Subject: RE: LU/10/25/PL - 78 Wick Street

Harry Chalk, MSc
Senior Planning Officer, Development Management

Reference	Location	Proposal	Status
LU/10/25/PL/78	78 Wick Street	Demolition of existing one storey dwelling from plot and reconstruction of a two storey new dwelling to enlarge the footprint of the existing dwelling, with additional office/storage space on the first floor, alterations to existing floorplates, and alterations of existing staircase layout, affecting the dwelling known. New application is as CIL Case 4 (New Roads) as part of development.	Submitted
LU/10/25/PL/78	78 Wick Street	Service of three year notice of proposed demolition of dwelling.	Approved Conditionally

Proposed Floor Plan

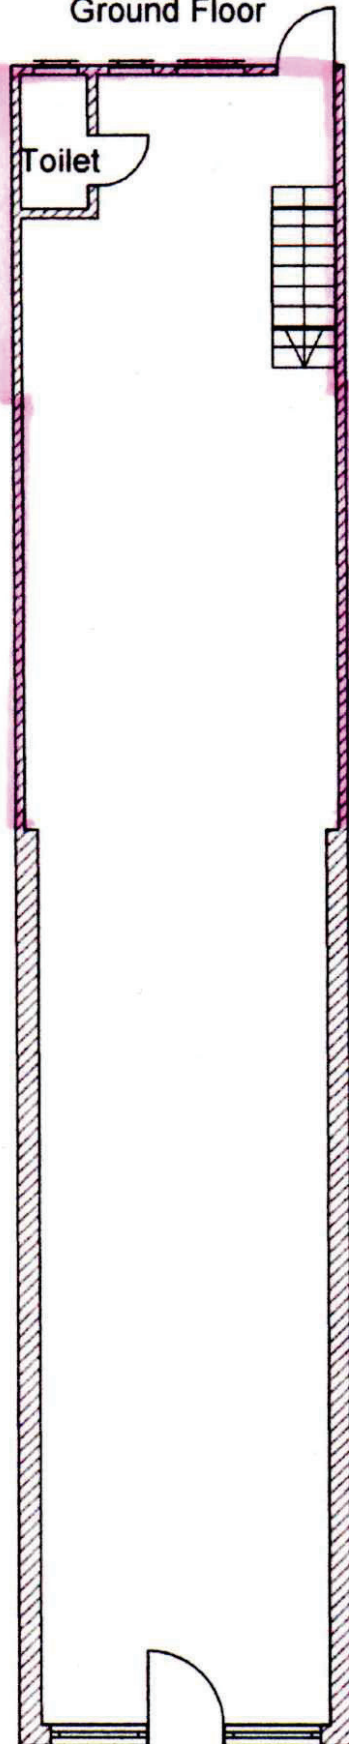
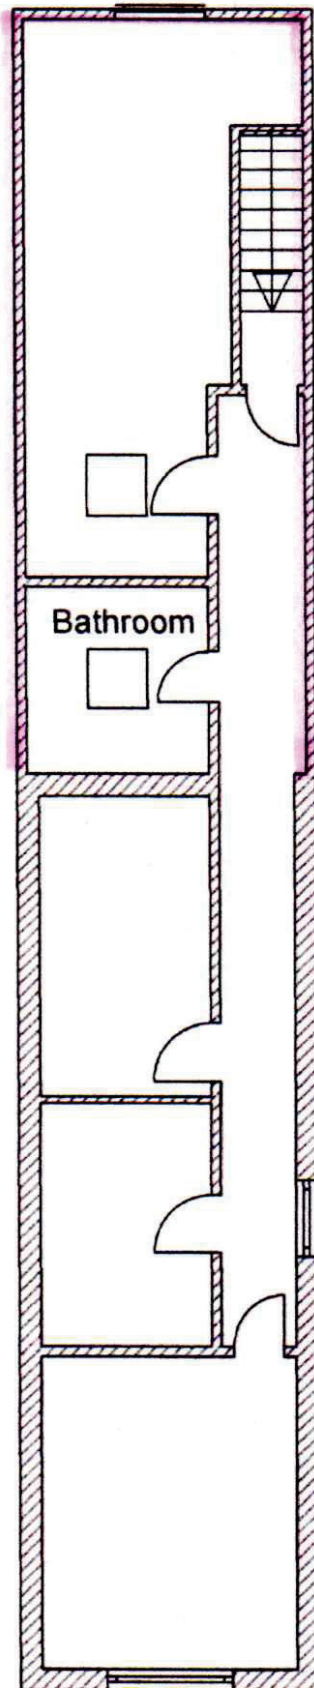
Thank you for your email and the amended plan. However, by way of update, and following on from our previous conversations, it is likely that we are to be refusing the application in the coming days on grounds of neighbouring residential amenity.

We understand that the first floor of No. 80 Wick Street (No. 80A Wick Street) is serving lawfully as a residential flat. I acknowledge the photos of the rear windows to No. 80A that you have sent through, which show closed curtains and a timber post against one of the glazed units, and I also acknowledge your reference to a brief conversation you had with the neighbour that indicates the rear first-floor room serves as a storage space at present. However, we have no cogent evidence of this room's current use, and the room is both likely, and assumed, to form part of the first-floor flat. Given the lack of evidence, its current use could be a habitable space, or even if it does currently serve as a storage space within the flat, it could easily become a habitable room at the whim of its occupiers, present or future. We have a duty to preserve the residential amenity of current and future occupiers of the residential flat, and the proposed extensions are likely to have unacceptable overshadowing and overbearing impacts on the main first-floor rear window of No. 80A Wick Street which would be harmful to the residential amenity of its occupiers.

We have concerns that the proposal would potentially be harmful to the residential amenity of occupiers of the first floor of No. 80/80A Wick Street. We are unclear as to the use of the first floor at this neighbouring property and what rooms the first-floor rear openings of the unit serve. We anticipate it may be a first-floor residential flat but have not yet been able to conclude this. Are you aware of the use of the first floor at No. 80/80A? and are you able to provide evidence of this use and what rooms the aforementioned openings serve? We need evidence to accurately assess the resultant impacts on the neighbouring unit.

**Proposed Floor Plan**

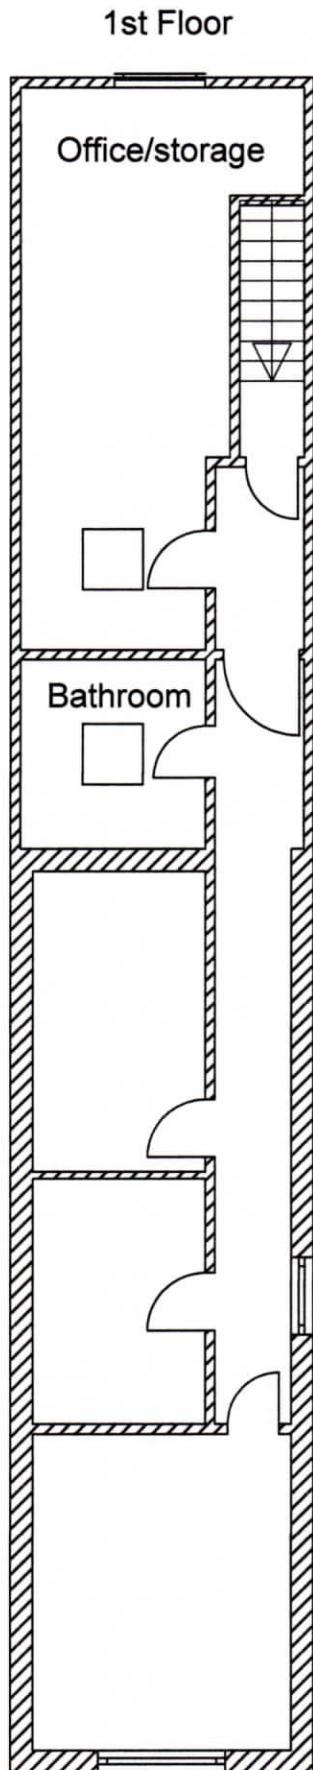
I appreciate you sending these through in attempt to address the concerns. From brief review, whilst these involve a reduction at first floor, the first-floor projection to the rear is still substantial and we do not believe this resolves the concerns sufficiently. In any case, and I am instructed not to accept substantial amendments to the application such as these as set out by our Customer Advice Note. We are happy to give some informal advice on amended schemes following determination and in advance of a resubmission, but if you would like formal and in-depth comment on any amended schemes, you are advised to submit a pre-application advice application ahead of any resubmission.
